CONSULTEE RESPONSE (Council's Arboriculturist)

Reference: EP/62/22/T

Location: 1 Kerry Gardens, East Preston, BN16 1HQ

Proposal: 1no. oak tree (T1) reduce crown from 11m to 8m in spread and raise crown to be approx. 4m above ground level. 1no. yew tree (T2) raise crown to be approx. 1.8m above ground level. 1no. cedar tree (T3) reduce southern side by 2m leaving tree approx. 8m wide, remove deadwood

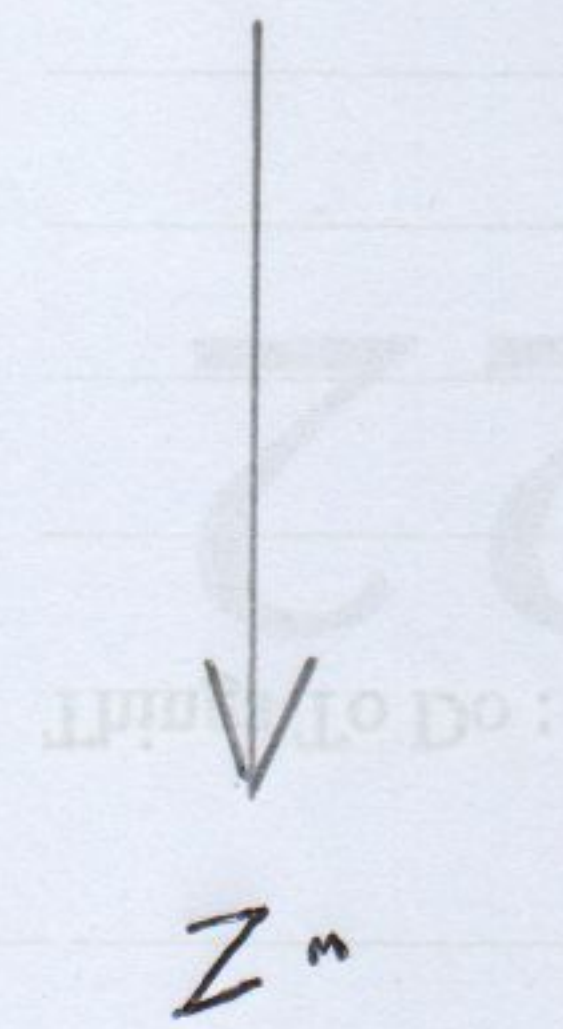
T1 has complex crown form, arising from historic loss of terminal leader and a pronounced kink low in the main stem. The applicant proposes to reduce its spread on all aspects, presumably to contain the tree's growth and at limited dimensions long-term. It has an attractive profile and is highly visible from numerous properties and to users of the public highway (footway and carriageway). Overhead clearance from low branches was not obviously problematic and mostly secondary (epicormic) growth on the main stem.

T3 It has an attractive profile and is highly visible from numerous properties and to users of the public highway (footway and carriageway). Low branches over neighbouring property will become problematic and so early intervention to prune smaller diameter branches is desirable.

T1 Reduction of crown spread and the removal of low branches to achieve 4m clearance above ground level has not been justified on arboricultural grounds. Such work would incur a loss of visual amenity.

As it stands, I am unable to support this application. I **would like the applicant to be invited to agree to a revised specification for lesser works on T1 (as described below) as part of the current application so as not to incur further delay.** Such work would go some way to addressing their concerns whilst preventing a diminution of the tree's landscape and public amenity value:

- Remove crown reduction pruning entirely from the proposal.
- Amend crown lifting specification to: *'Remove/reduce small diameter branches (<50mm) as necessary to achieve a maximum 3metres overhead clearance on all aspects.'*
